17 January 2022

**RE: SDP Submittal Letter of Intent – Slim Chickens Restaurant  
Falcon Marketplace, Lot 9**

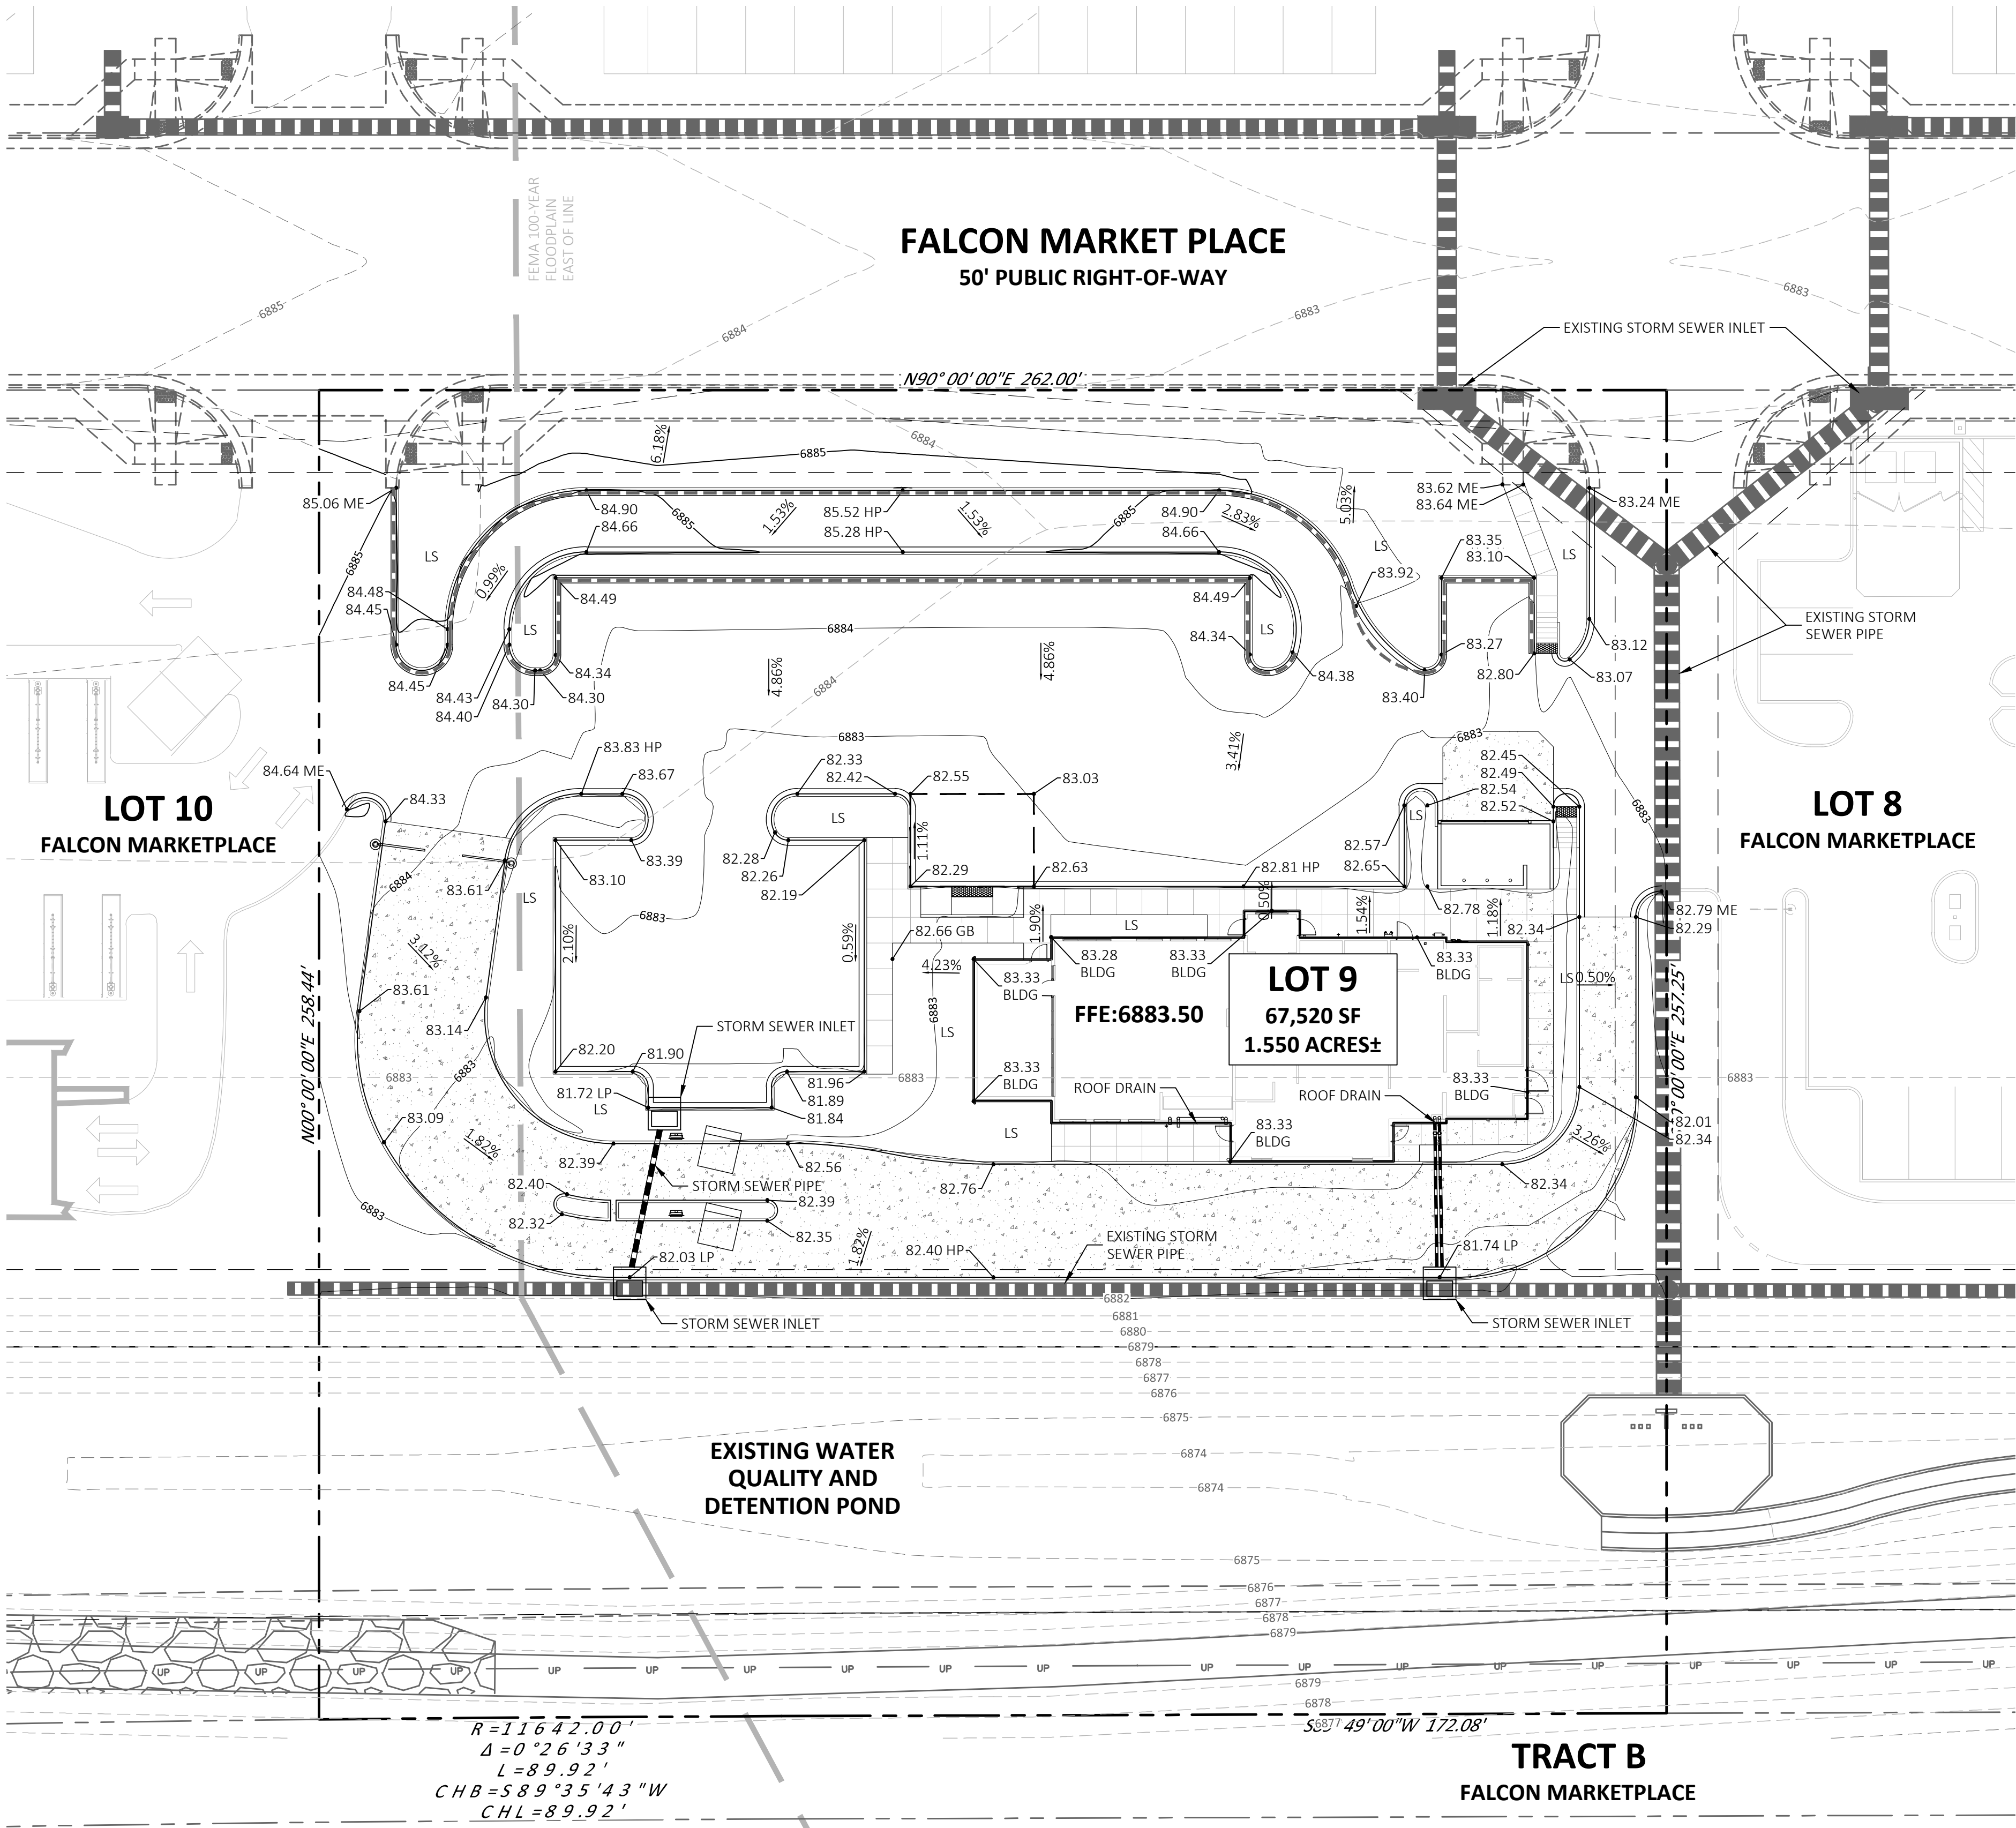
Site development plan still says 42 spaces required - 39 provided. Please revise either this letter or the site development plan to indicate the correct number of spaces.

I am not sure where this square footage comes from. Is this the interior dimension of the 3,902 minus the 278? It is very confusing to follow the math logic here and doesn't easily correspond with what is shown on the site development plan.
